Site: Rustington Golf Centre, Golfers Lane, Angmering, BN16 4NB.

Development: New retail unit with mezzanine together with associated car parking & service road
- This is a Departure from the Development Plan

Planning Application No: A/84/17/PL

Highways England Ref: HAMIS 77953

Distribution of Traffic on Wider Road Network (East of Site)

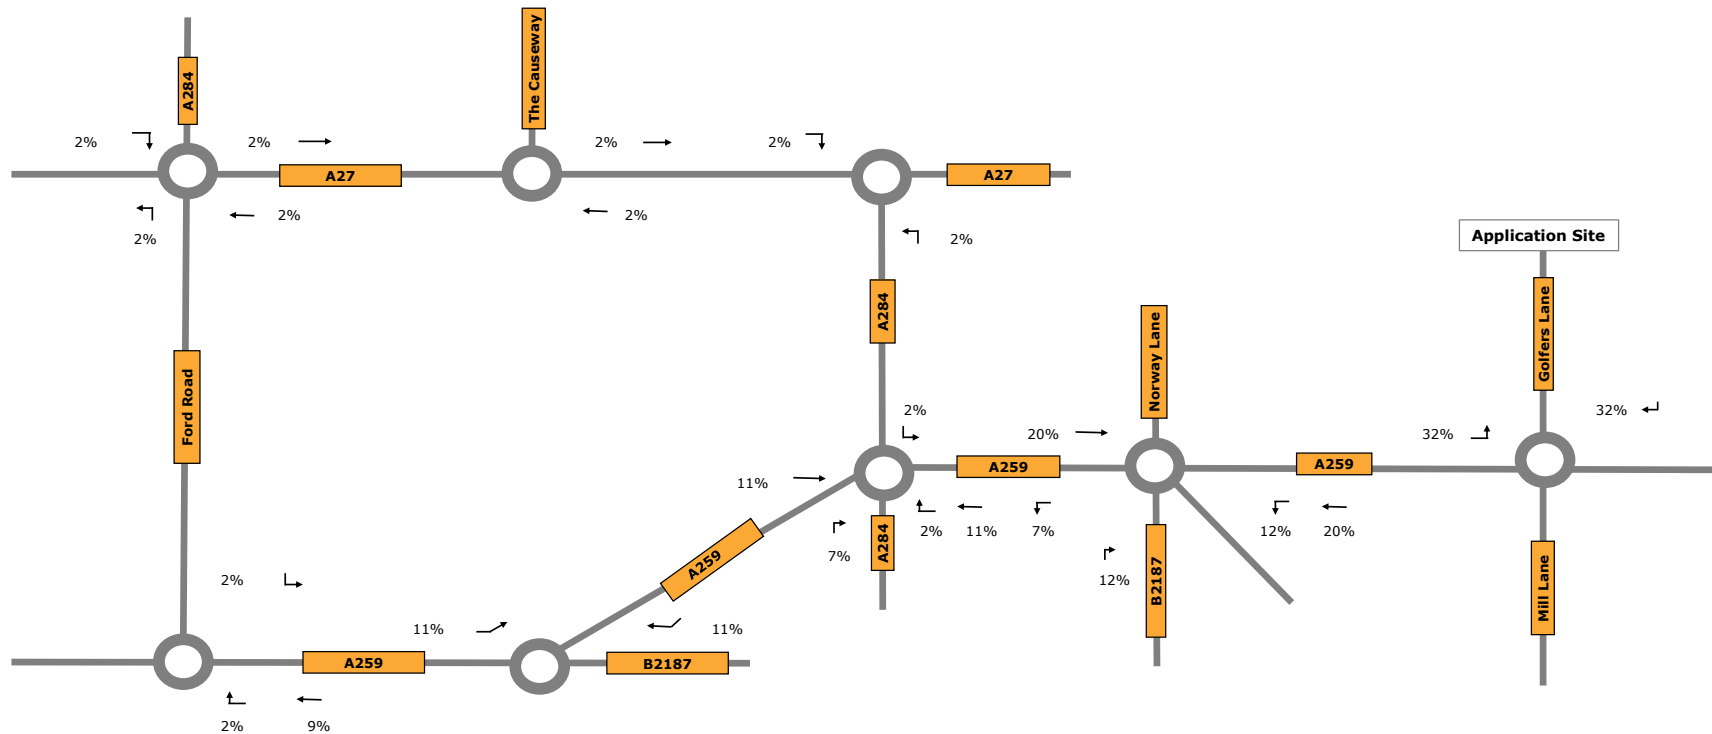
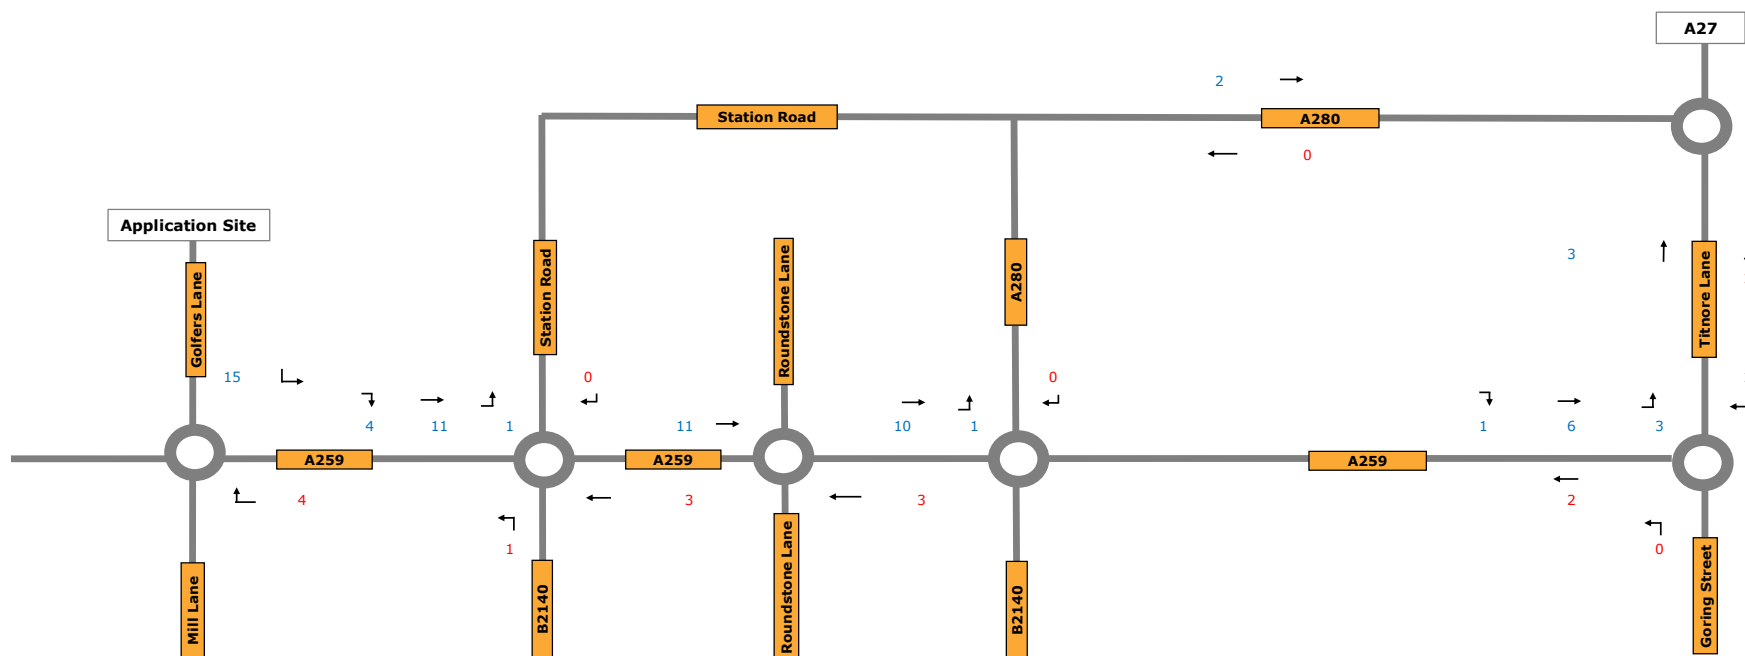
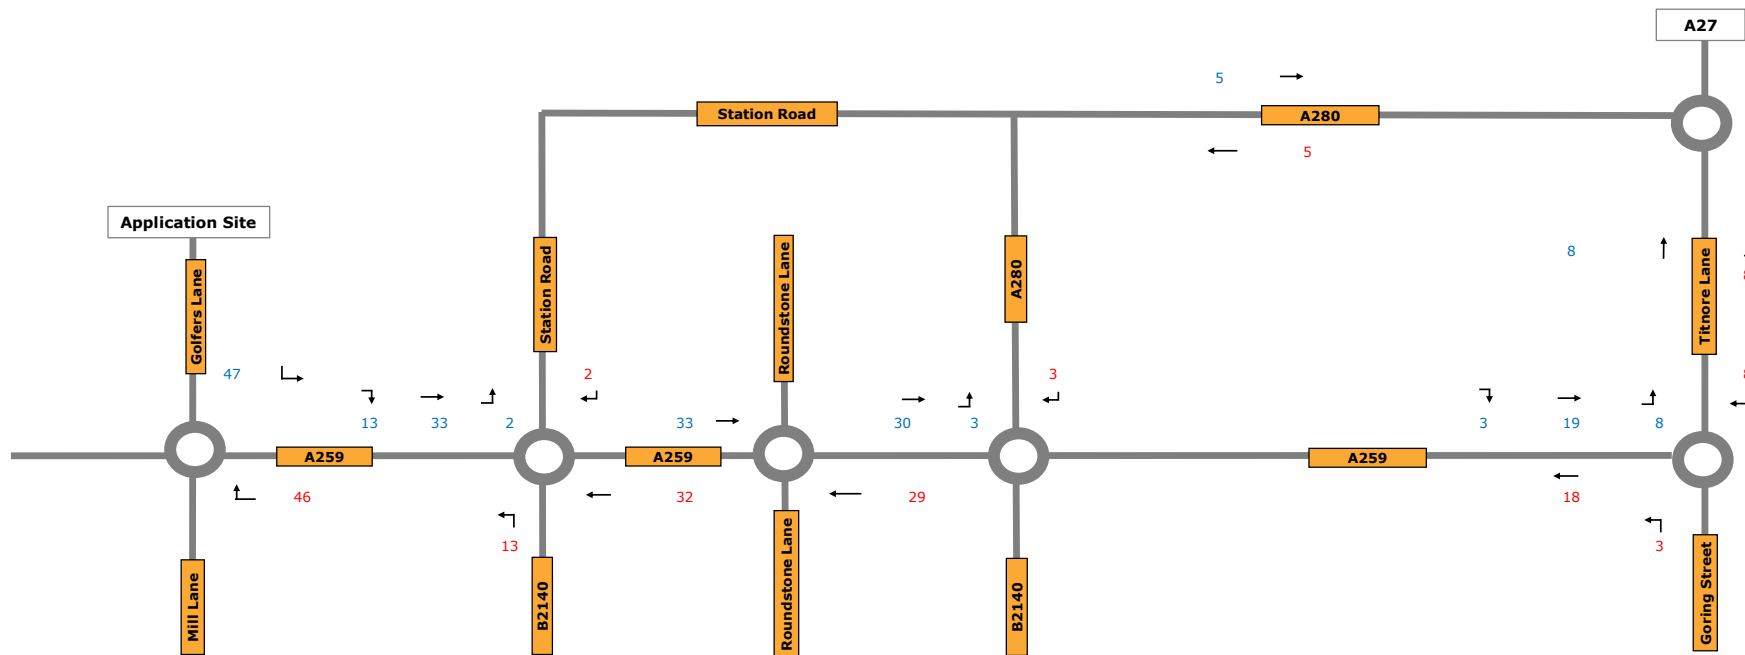
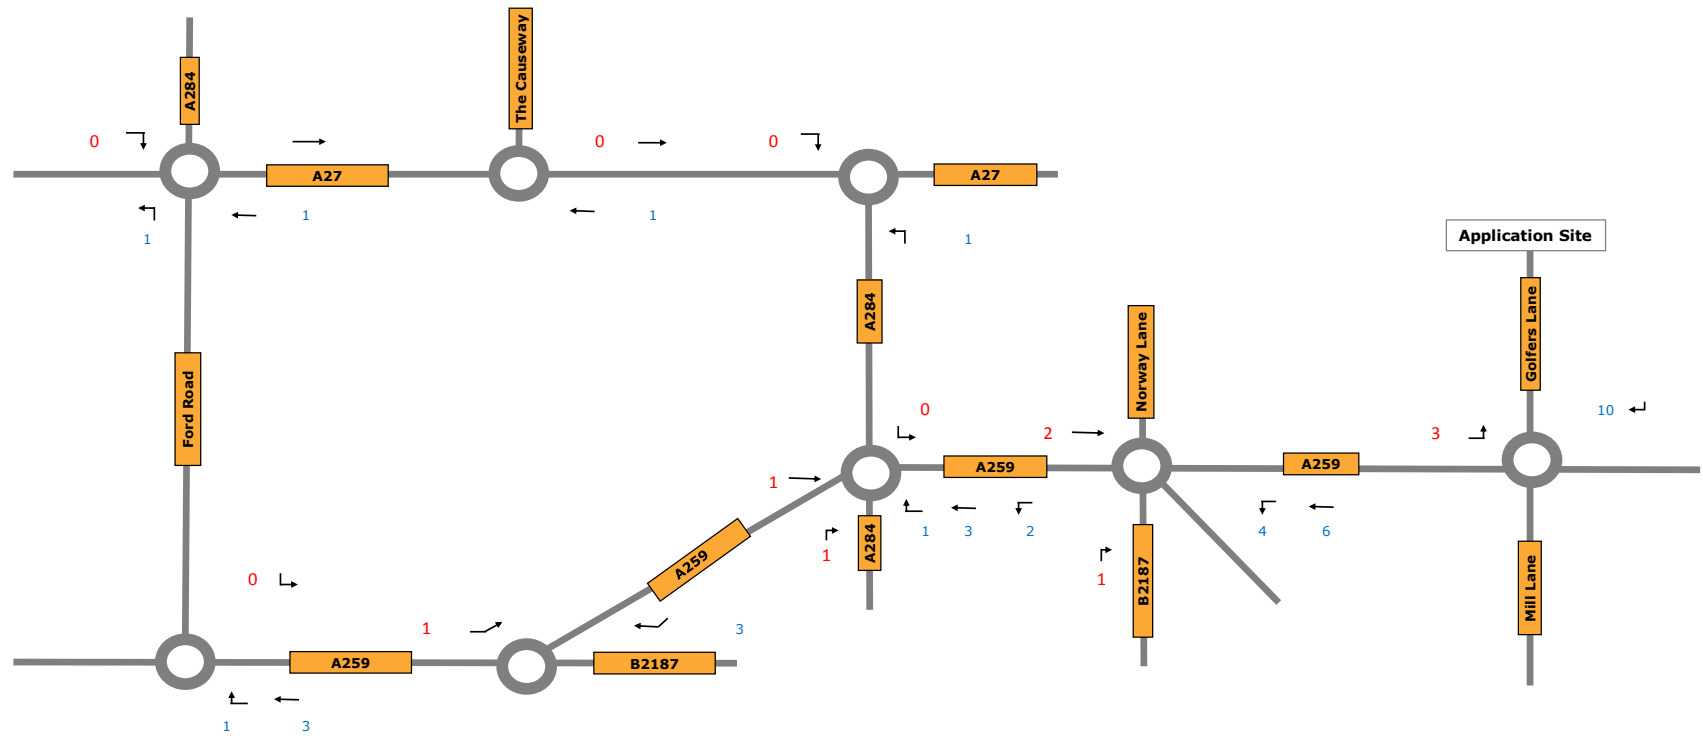
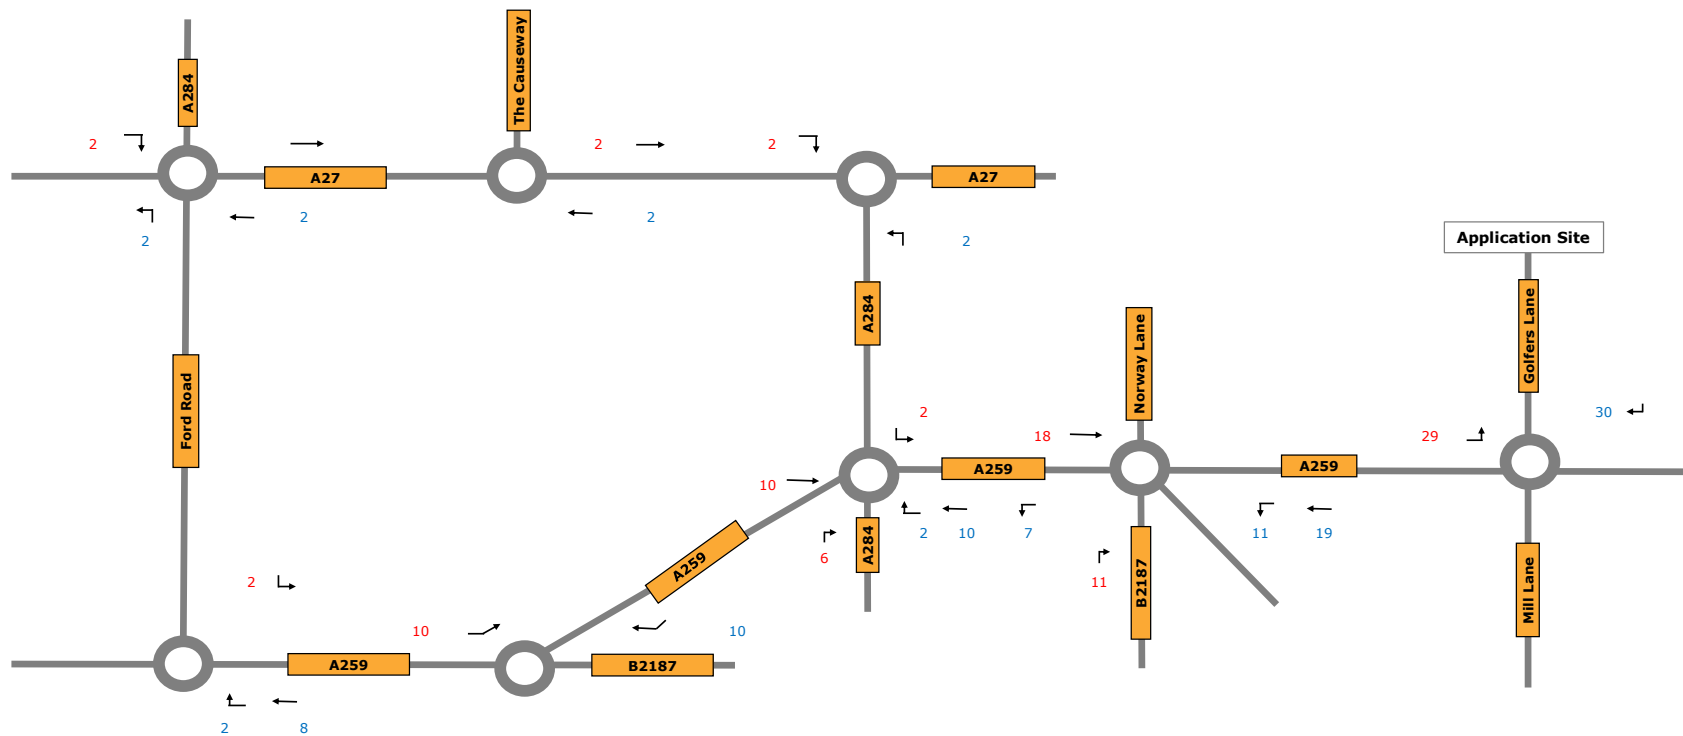
3. The distribution/traffic flows are not considered beyond the closest roundabout and thus it is not clear how many trips are expected to end up at the A27 and no consideration has been given to the impact of the proposed development on the SRN (A27), particularly in relation to the other strategic development contained within the emerging Local Plan.
